Application Ref:	3/2026/0027	 Ribble Valley Borough Council www.ribblevalley.gov.uk
Date Inspected:	N/A	
Officer:	LH	
DELEGATED ITEM FILE REPORT:		NON MATERIAL AMENDMENT

Application Description:	Non material amendment to application 3/2020/0601 to amend the wording of conditions 12, 13 and 17 to include a reference of the approved access drawing and alter the access width and visibility splays
Site Address/Location:	Land at Highmoor Farm Clitheroe BB7 1PN

client: morris homes
 project: highmoor farm, clitheroe
 project number: J329224
 scale: 1:500@A3
 drawing title:
 preliminary site access
 drawing number:
 J32-9224-PS-001

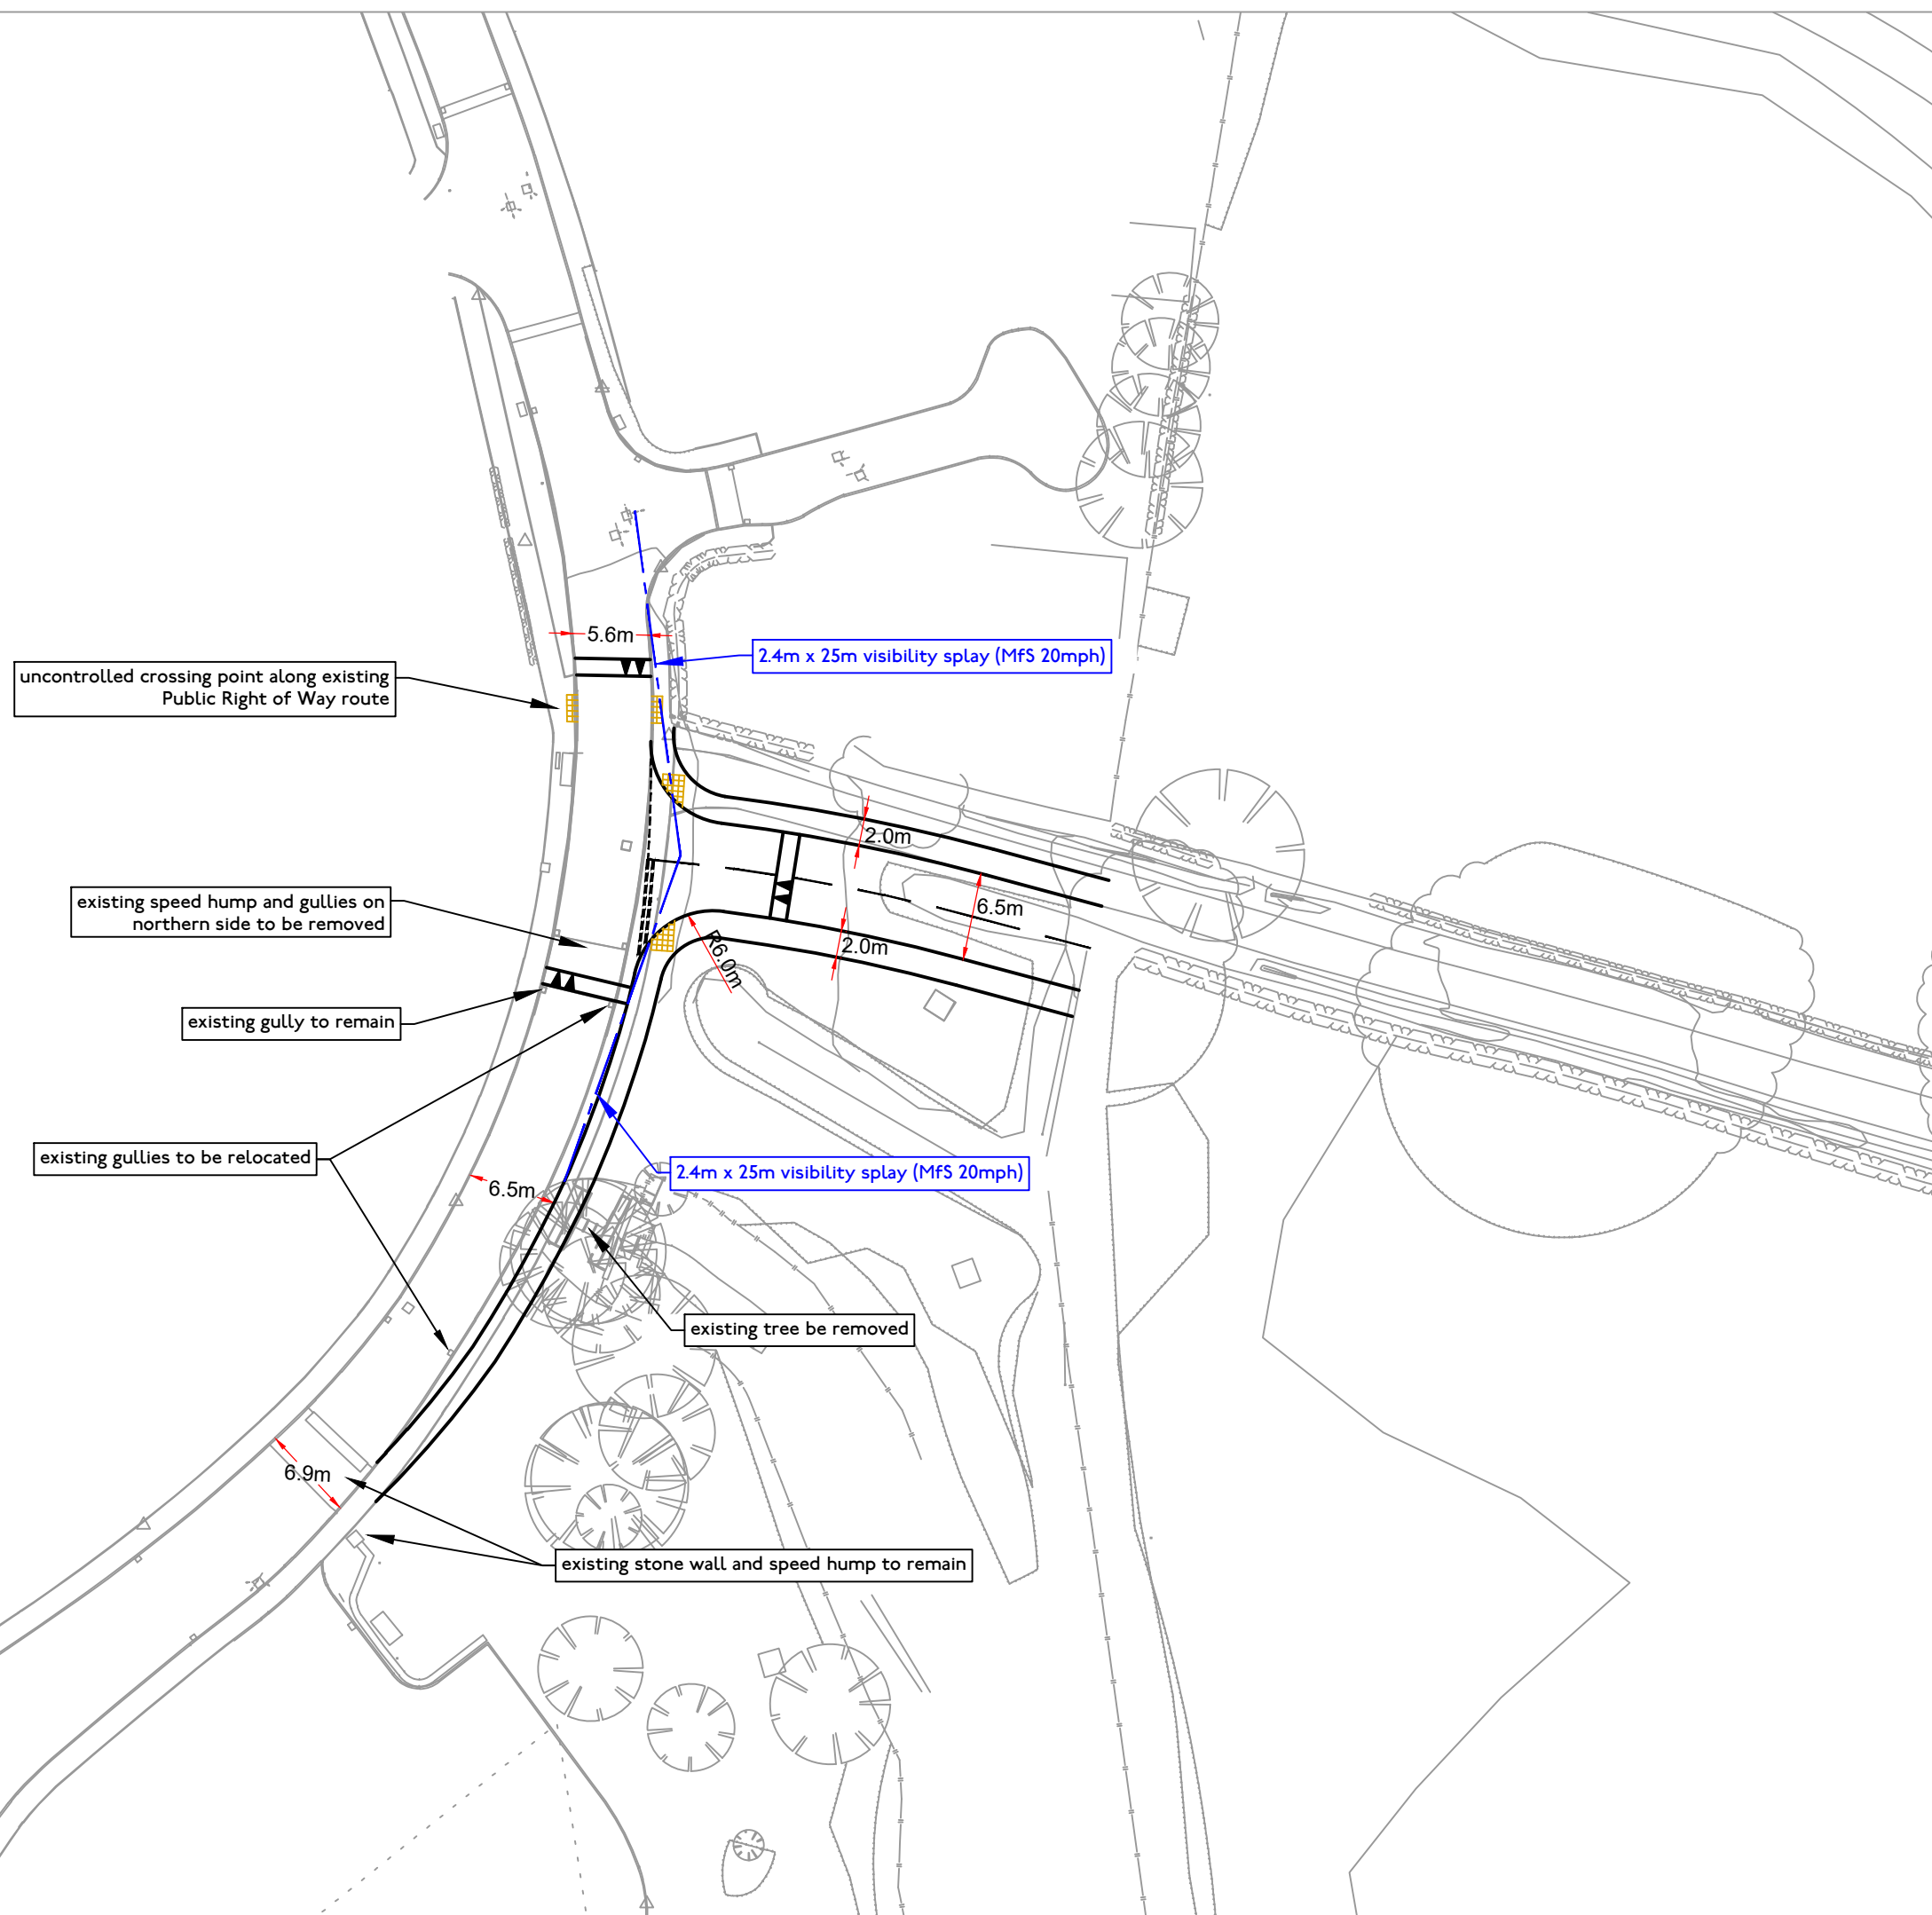
Condition 13 of the outline permission stipulates that the proposed access from the site to Highmoor Park shall be constructed to a width of 7.3m with 2m footways on either side. Further discussions with LCC Highways have established that the width of the proposed access road can be reduced to 6.5m and so the NMA application seeks to reflect this updated stance. Additionally the NMA application seeks to remove any uncertainty by including an access plan drawing reference in the condition.

Condition 17 of the outline permission stipulates that the visibility splays from the site access in both directions along Highmoor Park shall be 43m. Further discussions with LCC Highways have established that these visibility splays can be reduced to 25m and so the NMA application seeks to reflect this updated stance. Additionally the NMA application seeks to remove any uncertainty by including an access plan drawing reference in the condition.
